SUNNICA ENERGY FARM

EN010106

8.2 Proposed Changes to the Application

Version	Date	Status of Version
Rev 00	30 August 2022	Final

OPTION 2- 3.5m TRENCH WIDTH  
2 CABLE PER PHASE, TREFOIL FORMATION  
850mm CENTRES SEPARATION  
CIRCUITS 1 & 2

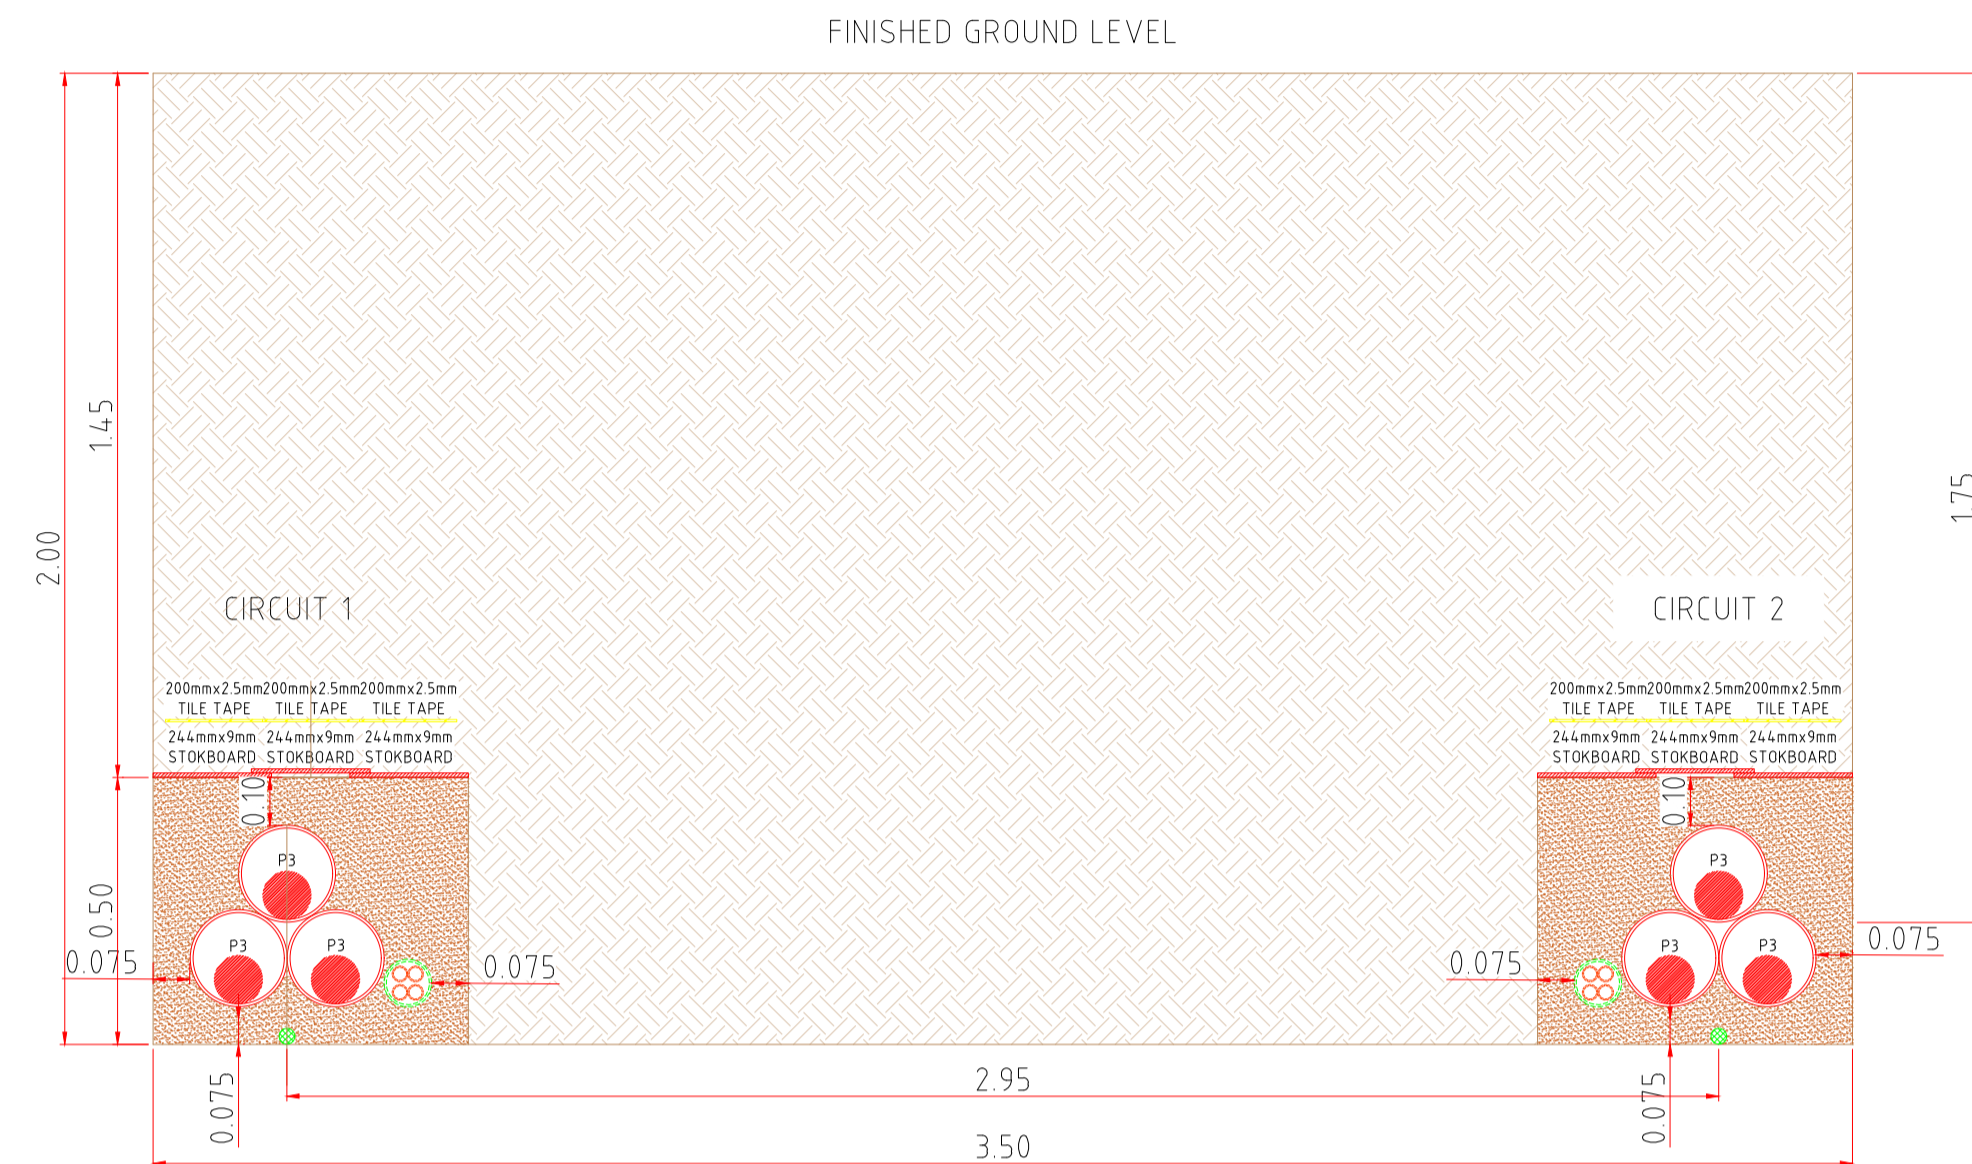
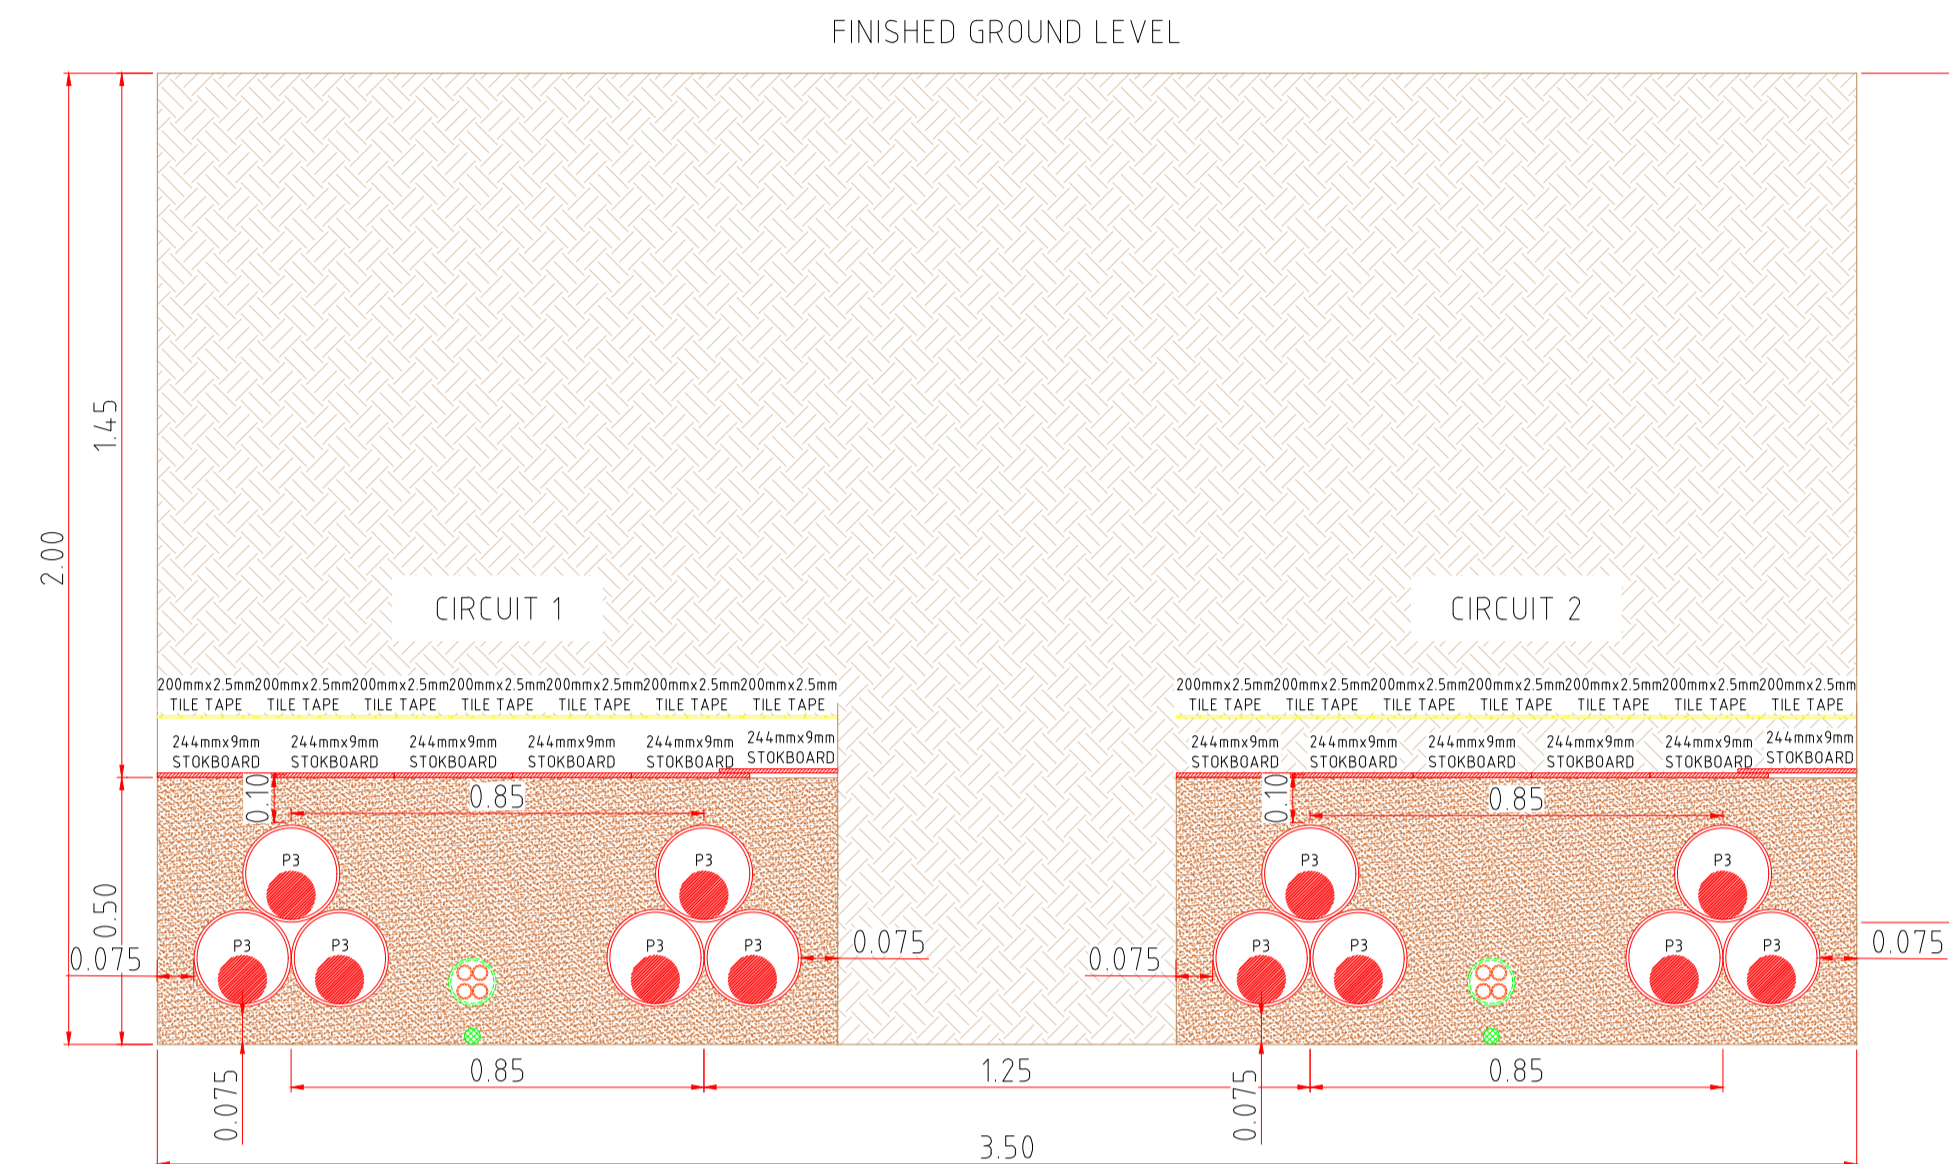
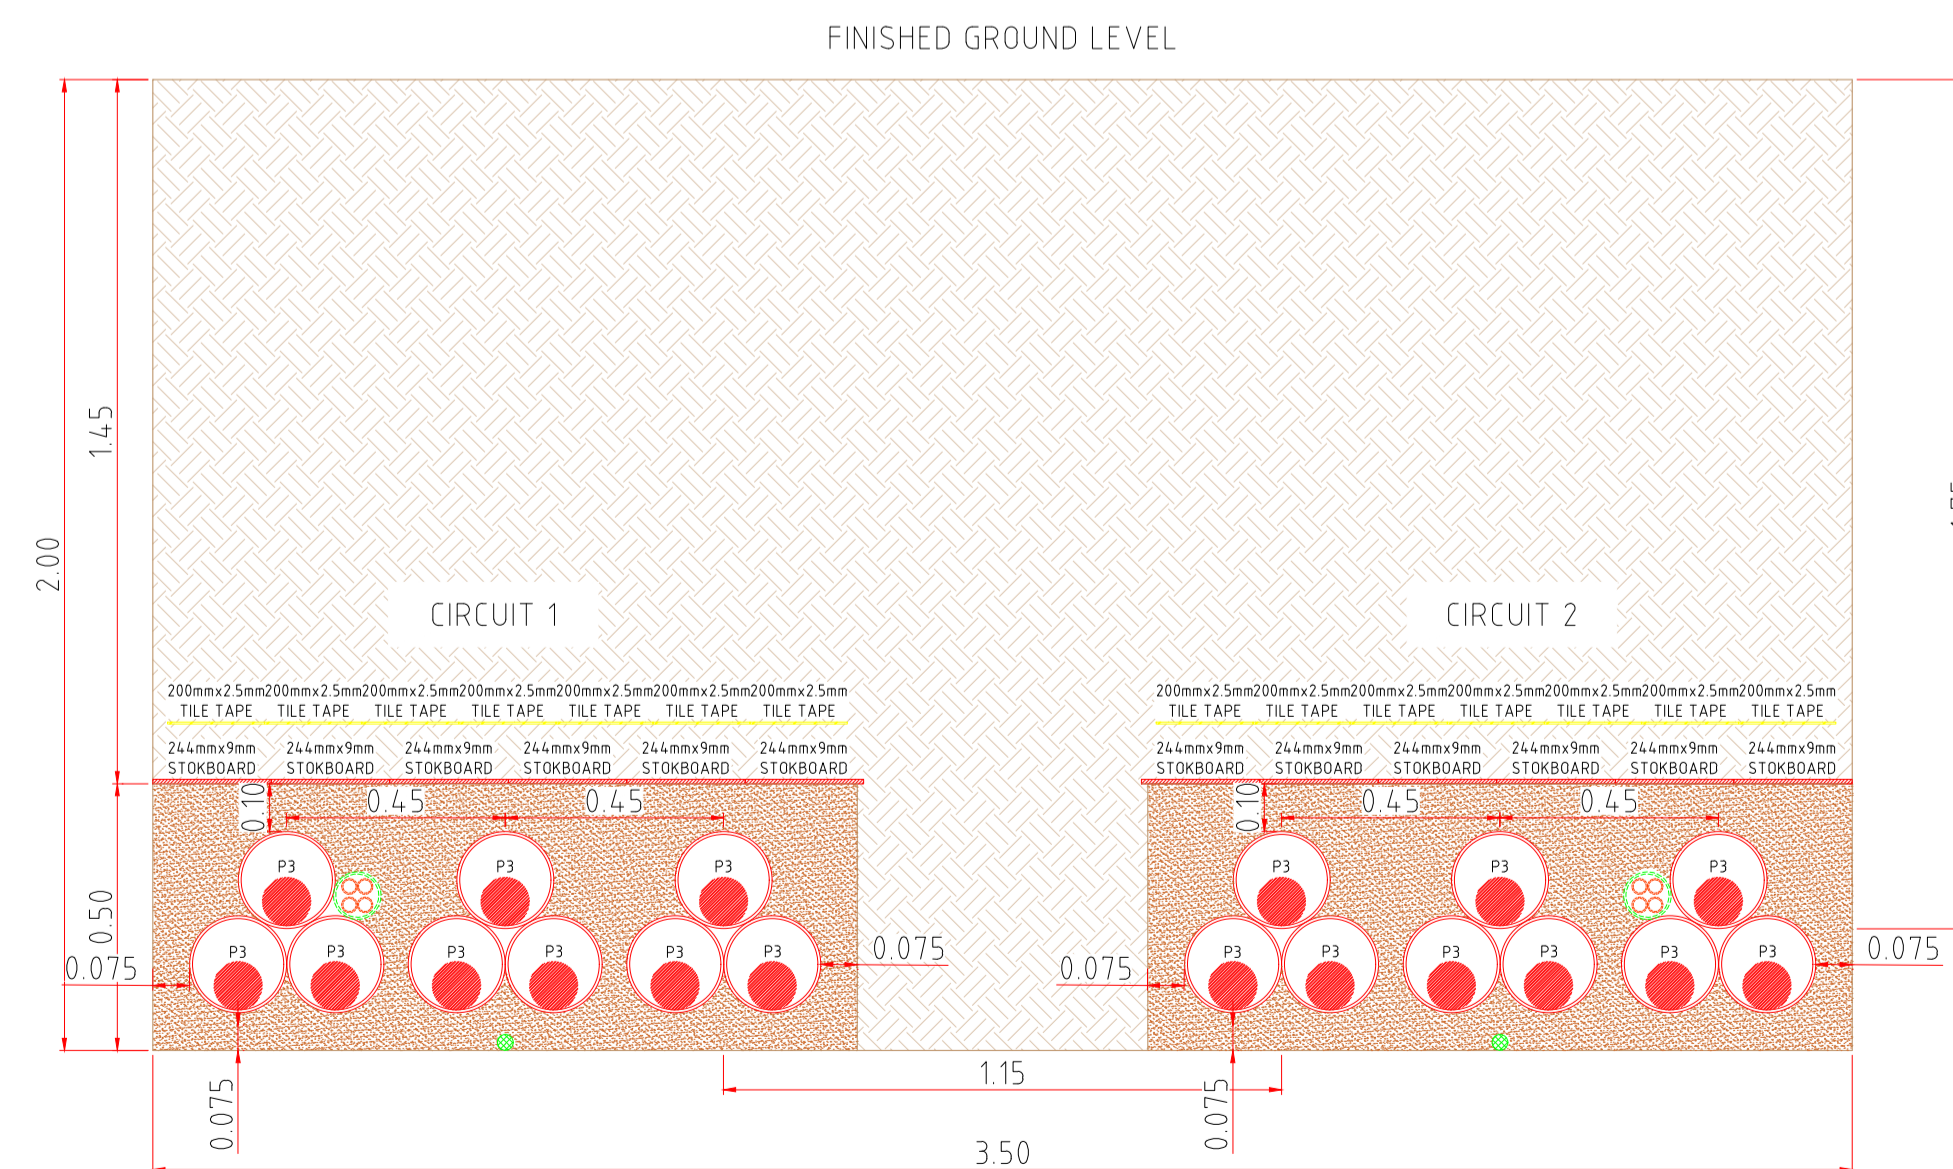
- a. Change 1 (NMC-01) – Removal of Option 1. Removal of the Burwell National Grid Substation Extension Option 1 from the Scheme.
- b. Change 2 (NMC-02) – 400kV cabling. Change to 400kV cabling within the grid connection routes (Cable Routes A and B) to facilitate grid connection Option 3 (described in Paragraph 2.17 below).
